From: [REDACTED]
To: [Norfolk Vanguard](#)
Subject: Written copy of oral submission made 24th April at Dereham
Date: 25 April 2019 10:33:33
Attachments: [Vattenfall ISH6 speech.docx](#)

Vattenfall Open Floor hearing 24th April 2019 7pm Dereham 6th form college.

My name is Julian Pearson. I sit on Holme Hale Parish Council and as per previous attendances with the inspectorate, represent the interests of the Parish Council here today.

Drawing file: published-documents / EN010079-001657-Figure 4.11 Onshore Project Substation Footprint Options.pdf

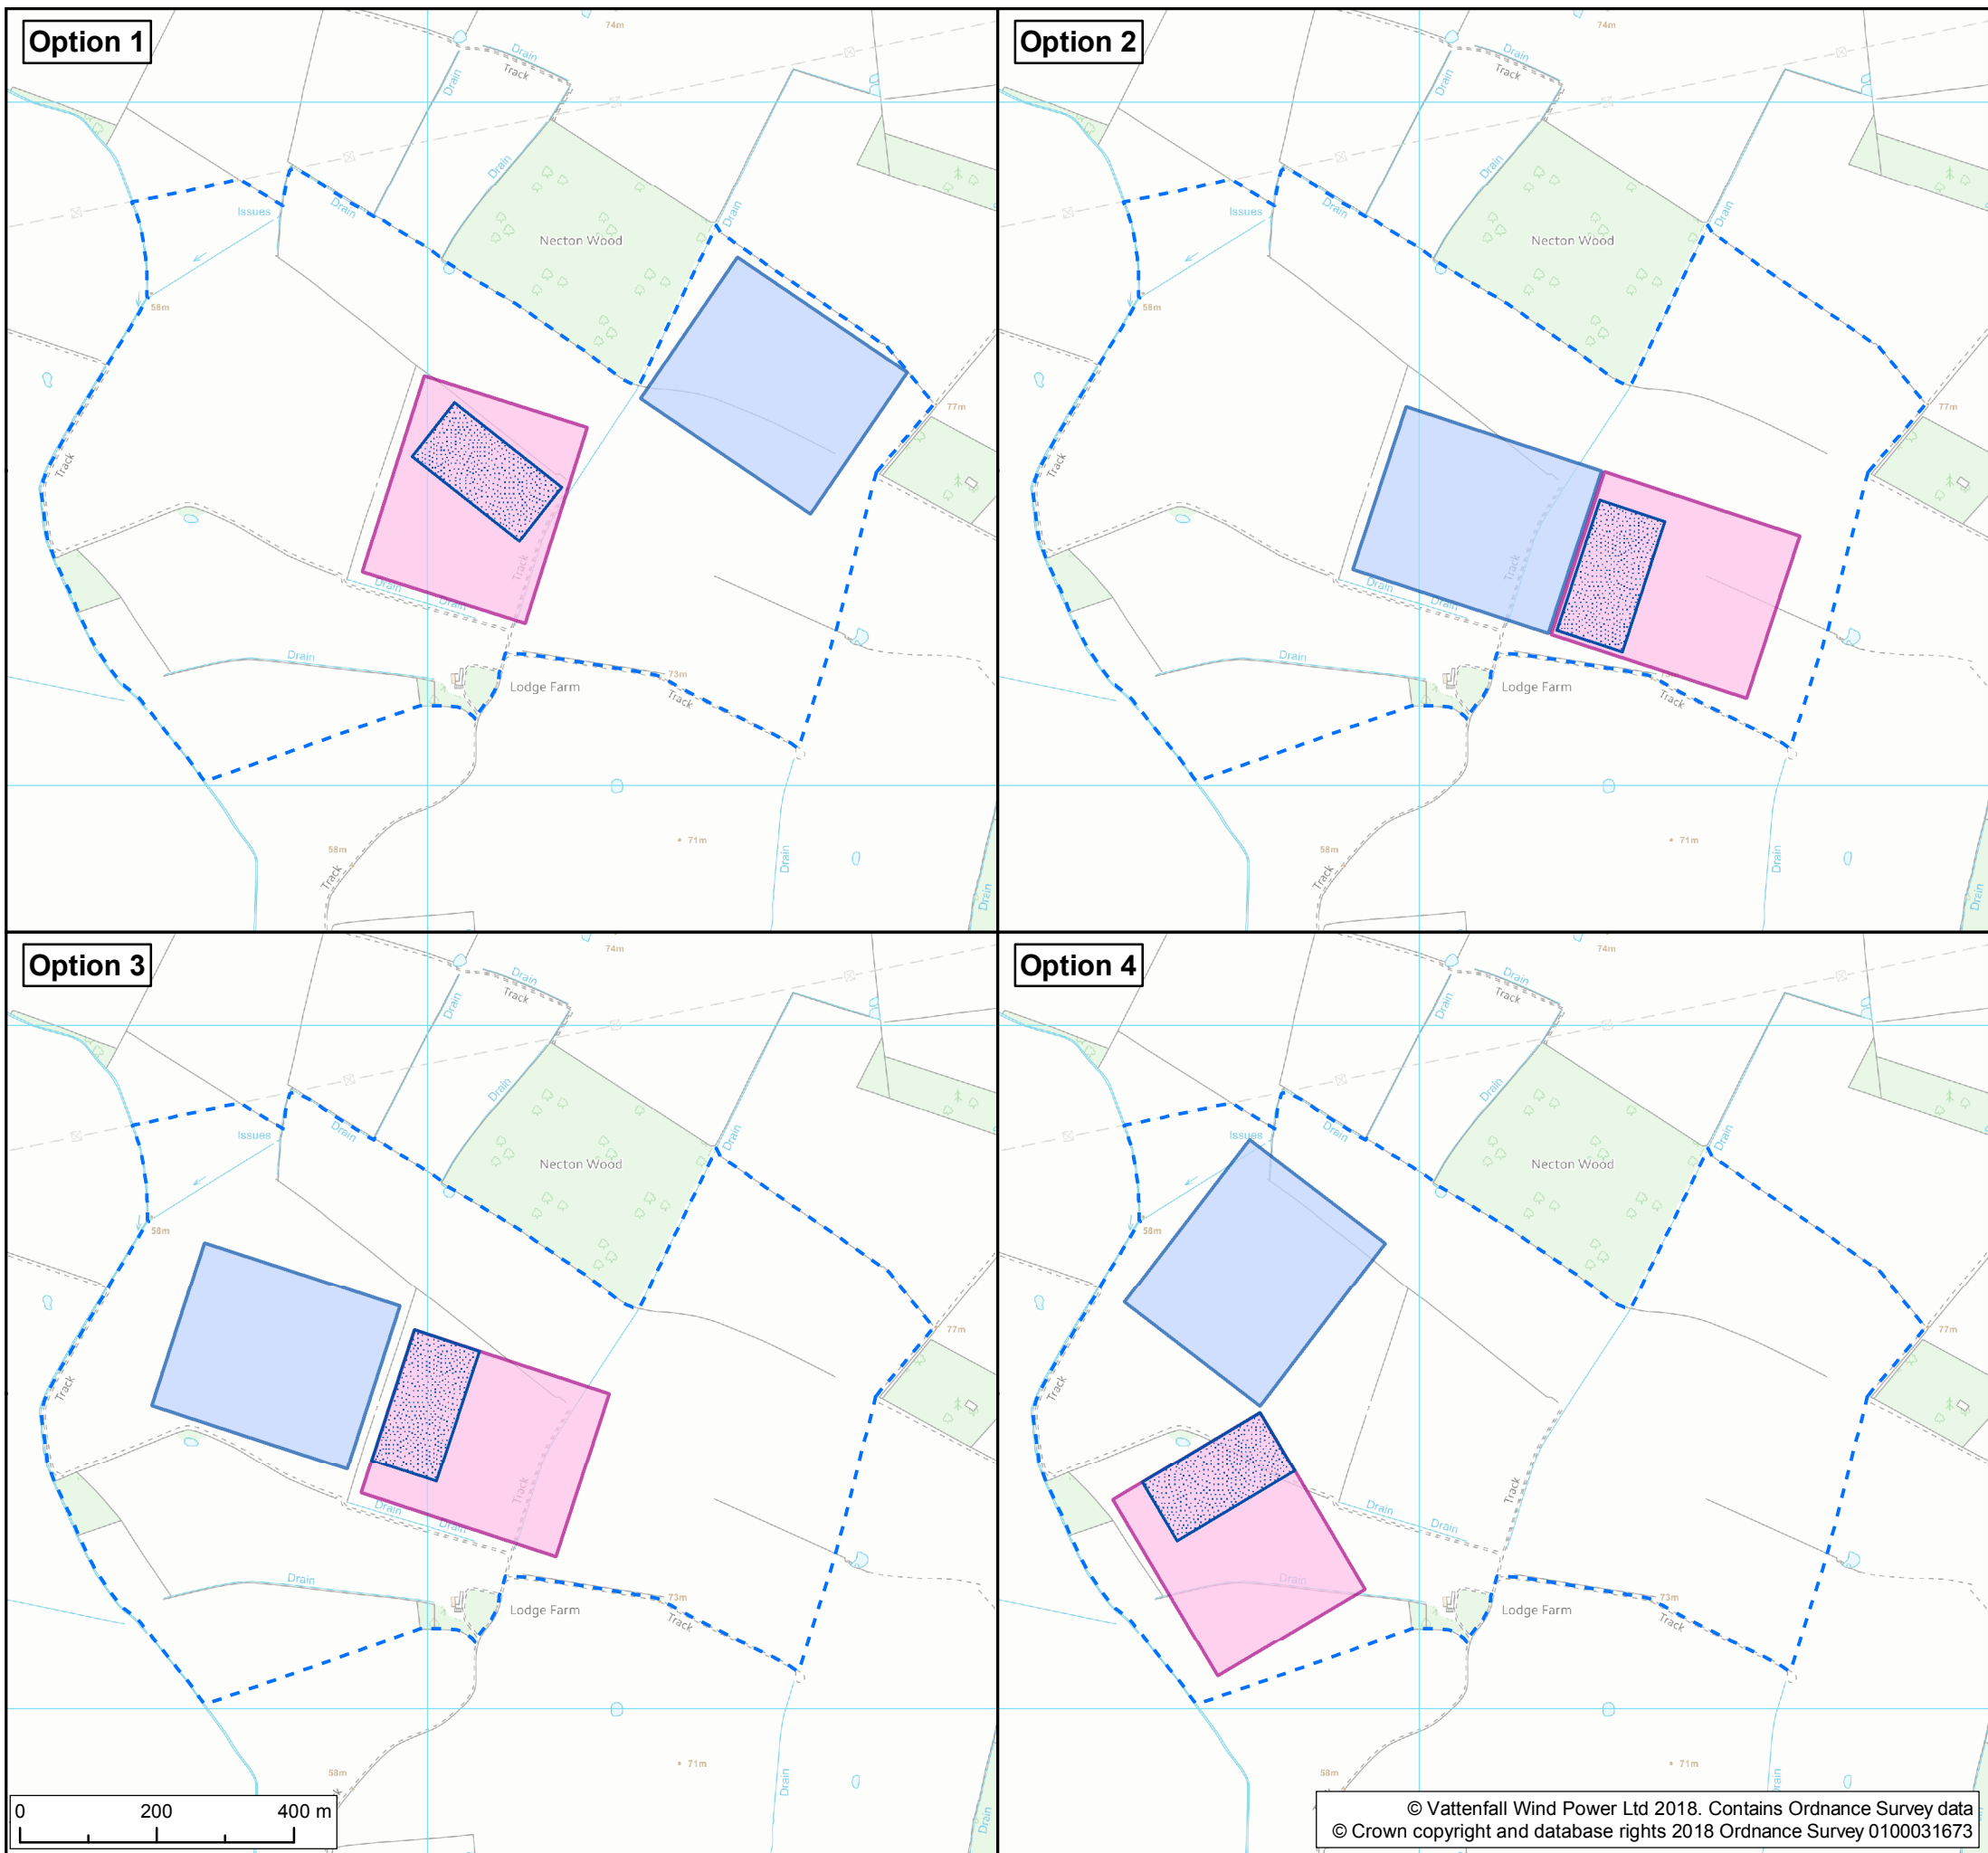
The term “wherever possible” must be code for “but we can’t actually achieve this”, given the two 19m tall buildings and the 25m lightning towers in their proposal.. but lets set that aside..

I mention this, because formal requests for details about the development have been long standing.. more recently, requests were submitted by a member of the Little Dunham Parish Council (Mr Ian Harding) regarding the length and width of the proposed buildings, to be met with the all too common ‘we do not know yet’.

As a consequence, we find ourselves here today, debating the potential impact of a ‘rough representation’, not a factual design, to which end, any responses the applicant makes, are of equally limited value.. and zero commitment, with a “We didn’t do it that way, so it’s not relevant” type scenario, waiting in the wings.
